7-27 Circular Quay West, The Rocks

22 June 2018

RESPONSE TO SUBMISSIONS

BAY 11 ROOF - SSD7056 MOD 2 MODIFICATION TO CAMPBELL'S STORES 7-27 CIRCULAR QUAY WEST, THE ROCKS

01 EAST ELEVATION  
SCALE 1:200

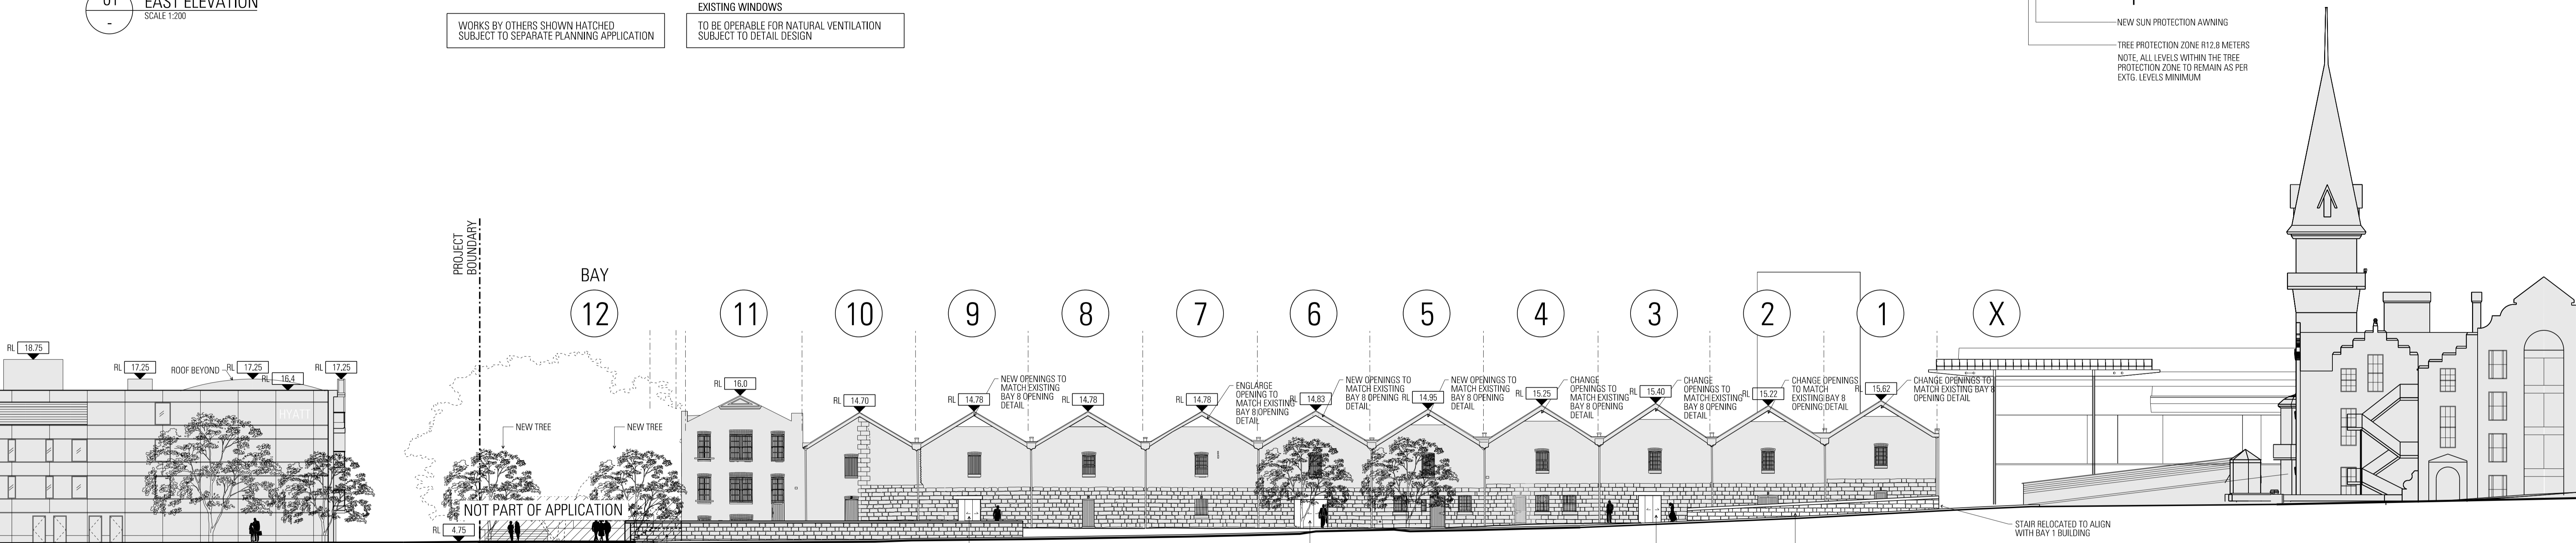
We also refer to the correspondence from the Heritage Division, as delegate of the NSW Heritage Council, dated 29/05/18, that questions works to the east facade of Bay 11, being:

- The replacement of a flat sheet panel and a louvre, with a new louvre, to the Dutch gable of the Bay 11 roof, east elevation, so as to maximise air intake to the mechanical plant in the roof space. The proposed waterproof louvre is powdercoat aluminium in a charcoal colour.

- The proposed replacement of the Bay 11, east Dutch gable front face with a new louvre will have an acceptable heritage impact.
- Given the intention to enable a sustainable use of the Campbell's Stores building with a workable mechanical system, the increased size of the covered openings relative to the alternatives, provides mitigation in heritage terms.

Drawing Title  
**ELEVATIONS**  
JPW Project Number  
**12006**  
Drawing Status  
**EA**  
Drawing Number  
**EA-A-2000**  
Revision  
**D2**

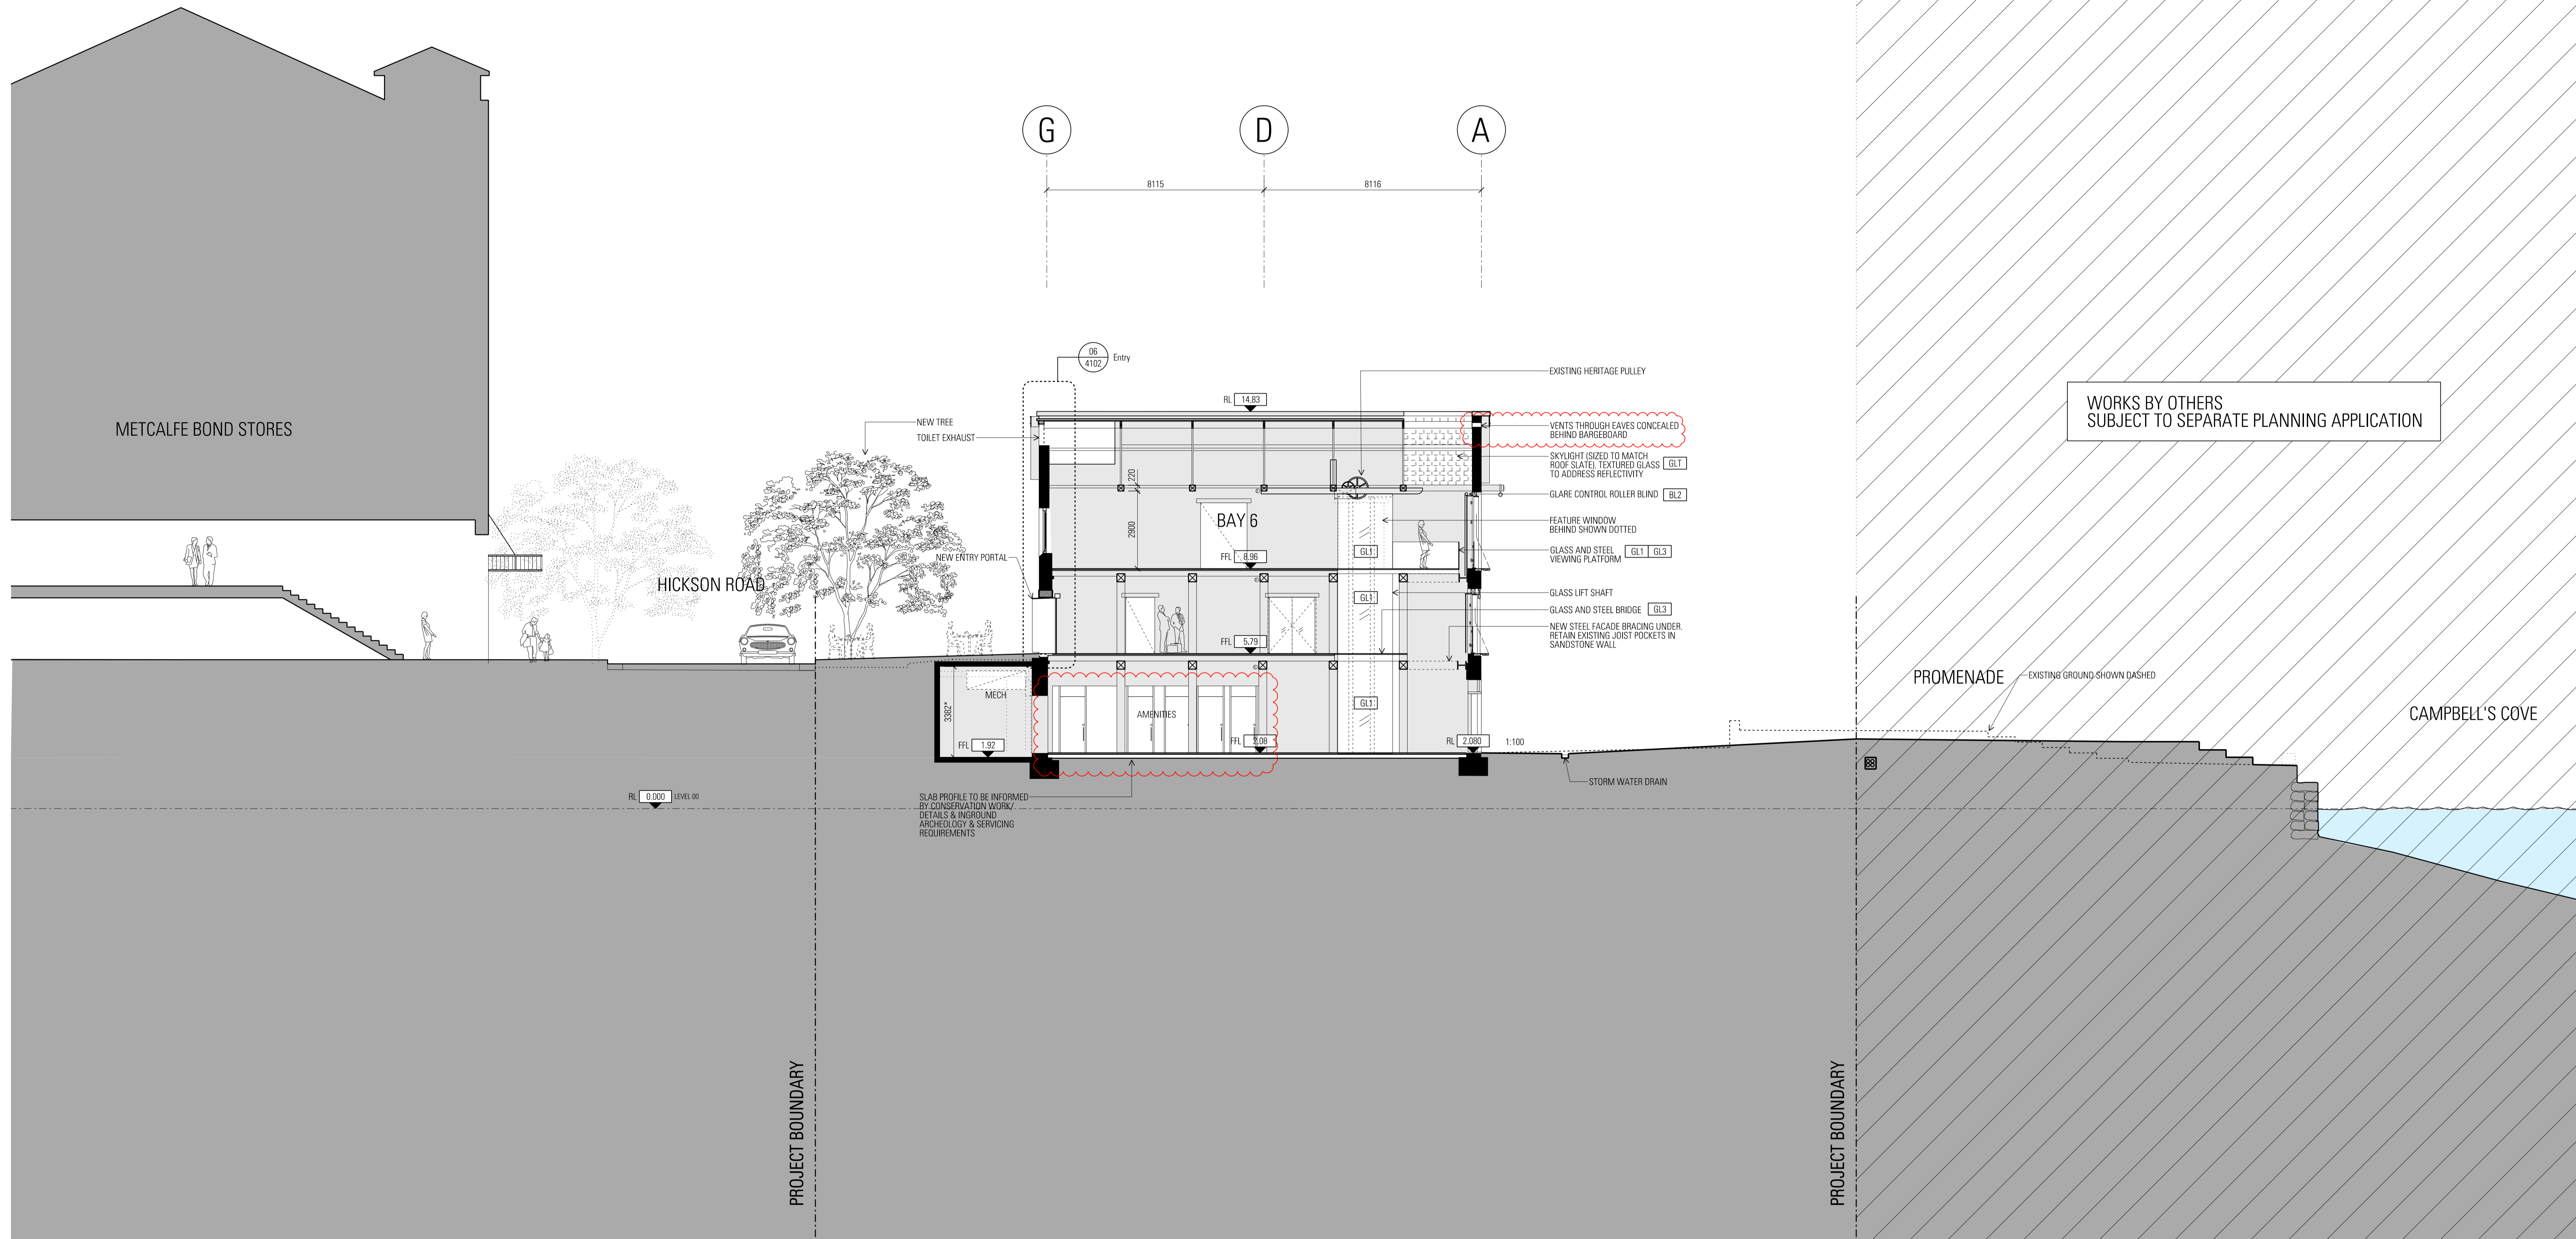
<p>Heritage Council comment</p>	
<p>Bay 11, east facade louvre replacement to the Dutch gable</p> <p><i>Image Source: JPW</i></p>
